March 9, 2016

**Subject: 421 Warren Avenue
Amended Plan Submission – Safelight AutoGlass™**

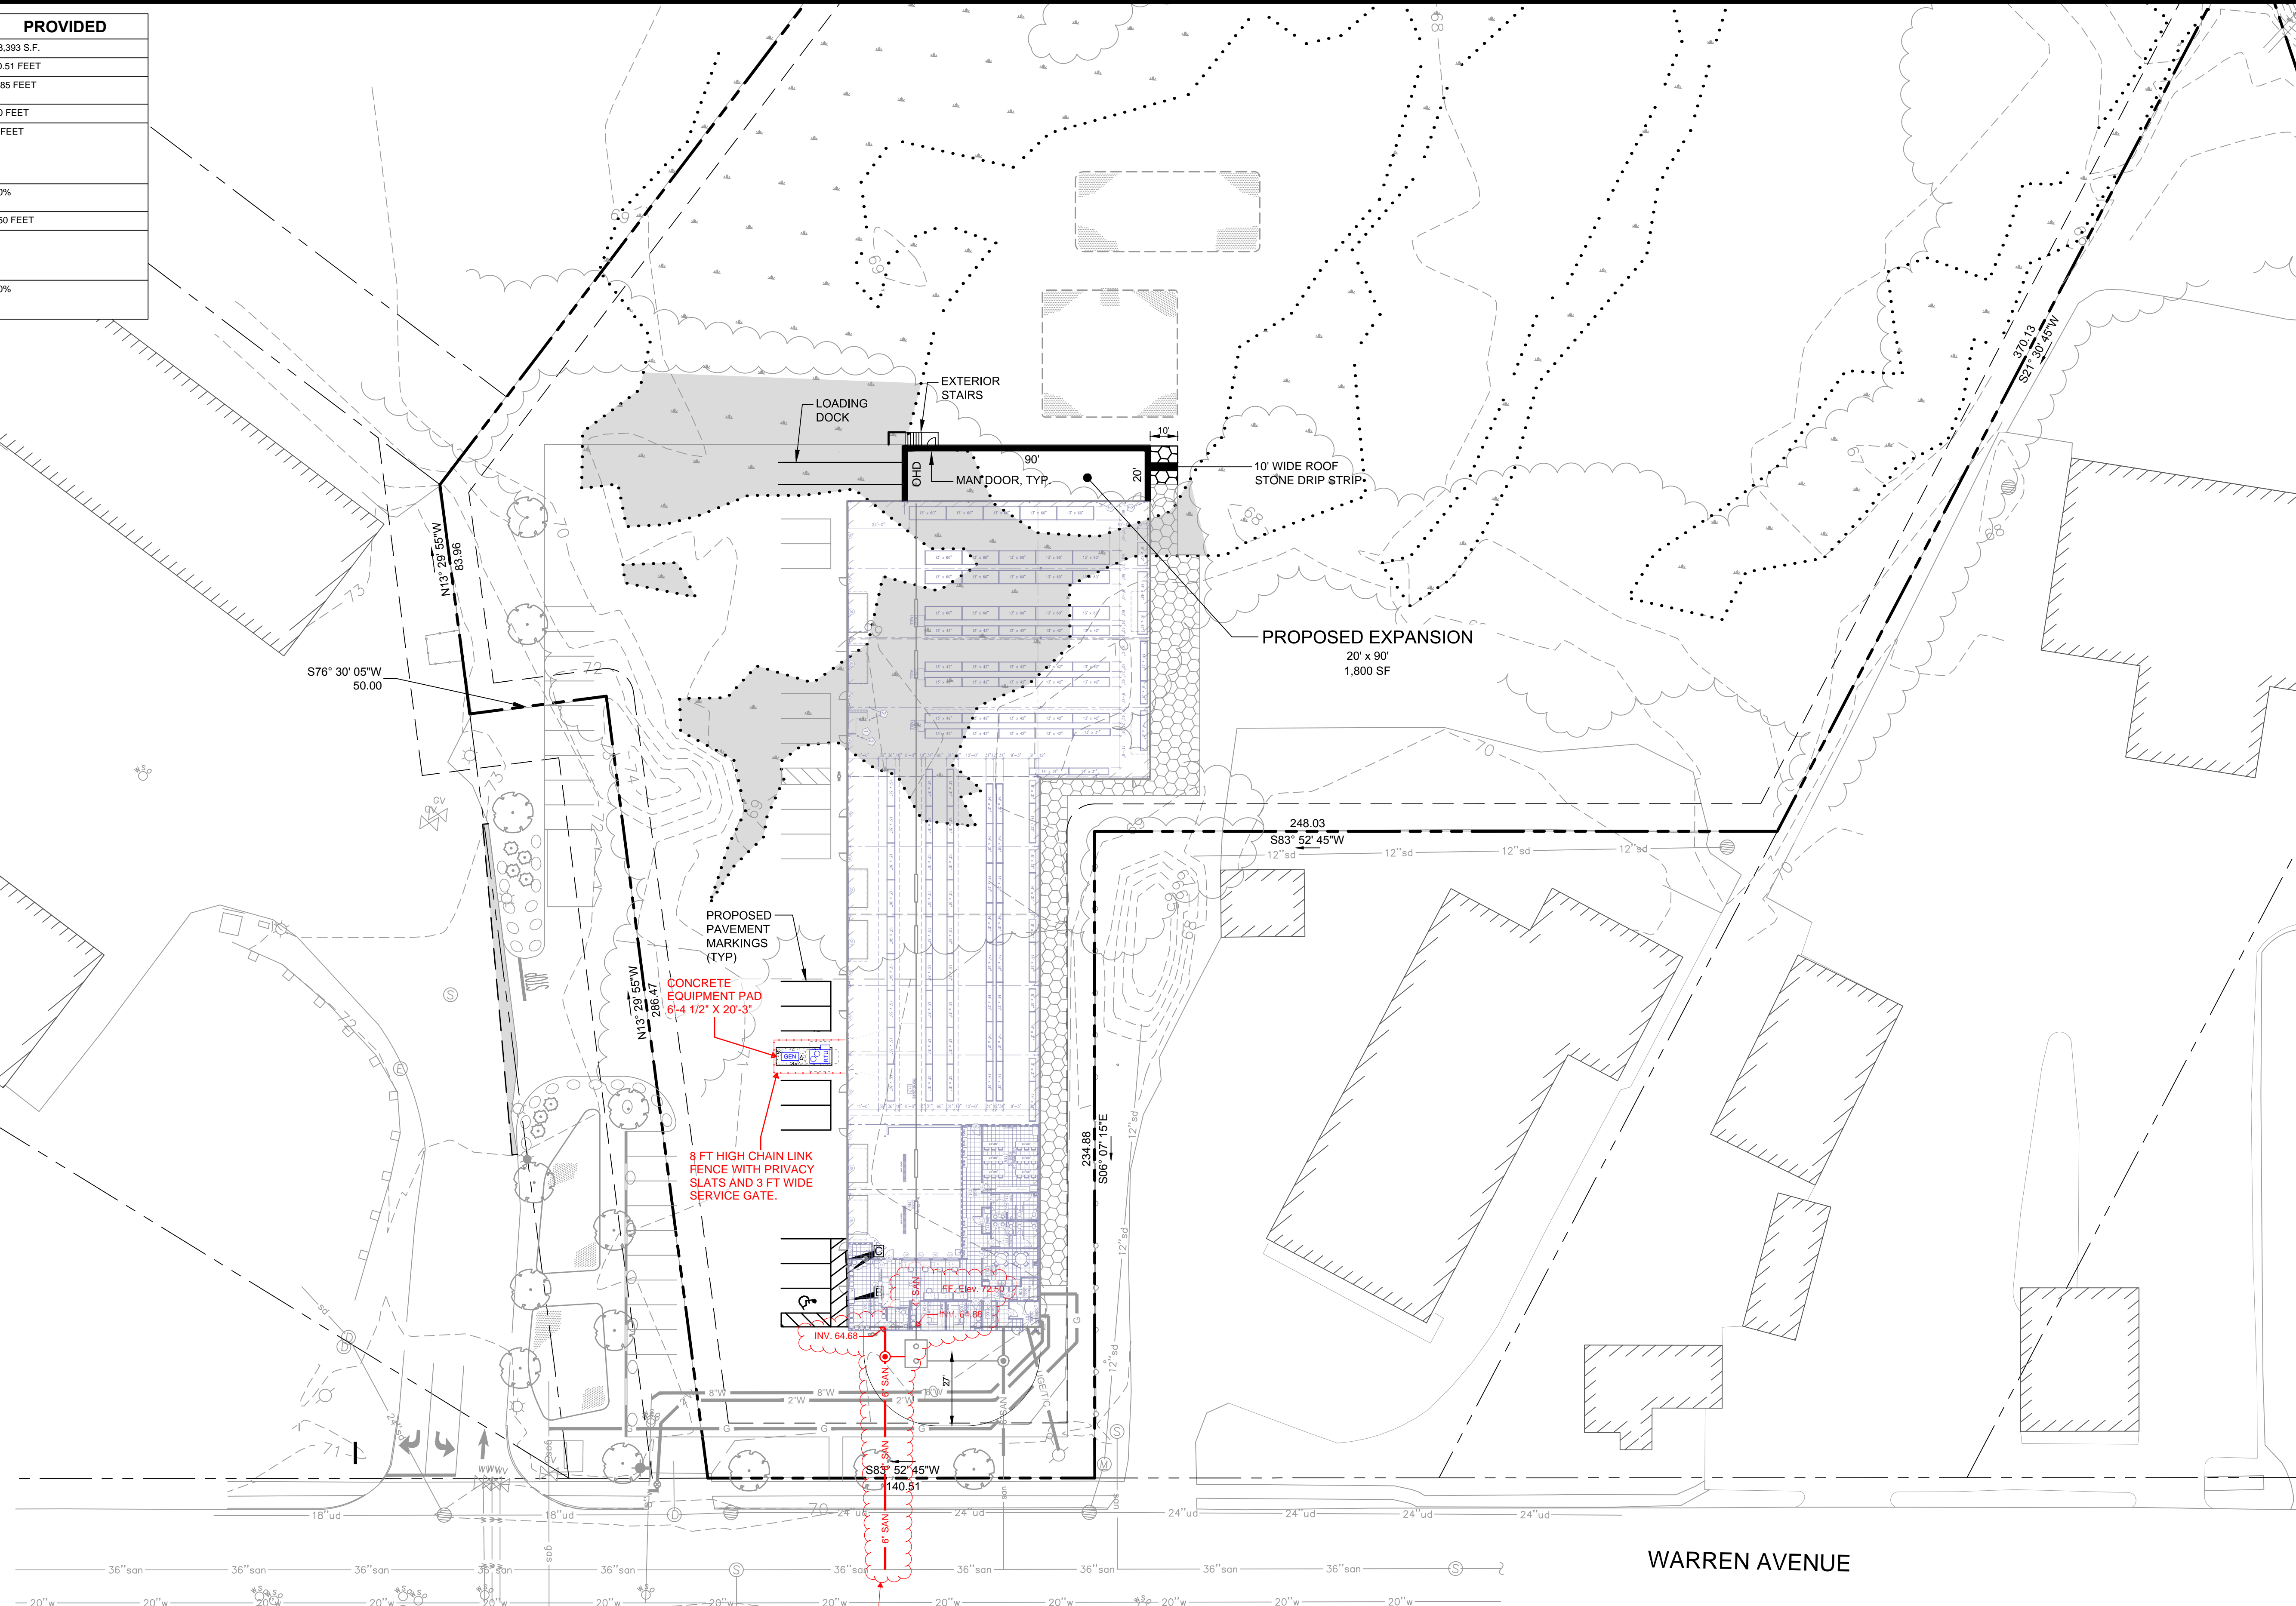
Per our recent exchange of email's we've relocated the positioning of the proposed generator per the accompanying revised site plan. The generator will be located on the west side of the building and away from the street front. We selected this location as it is preferable versus the rear (north) end of the site, which is too far from the electrical room, has conflicts with the drainage systems and wetlands and the presence of residential properties north of the site, albeit at a distance, is also less desirable in our opinion. For this reason we propose to locate the generator to the west side and screen it with vegetative plantings. Based on the manufacturer's noise data we believe the generator satisfies all City regulations pertaining to noise levels at the property lines.
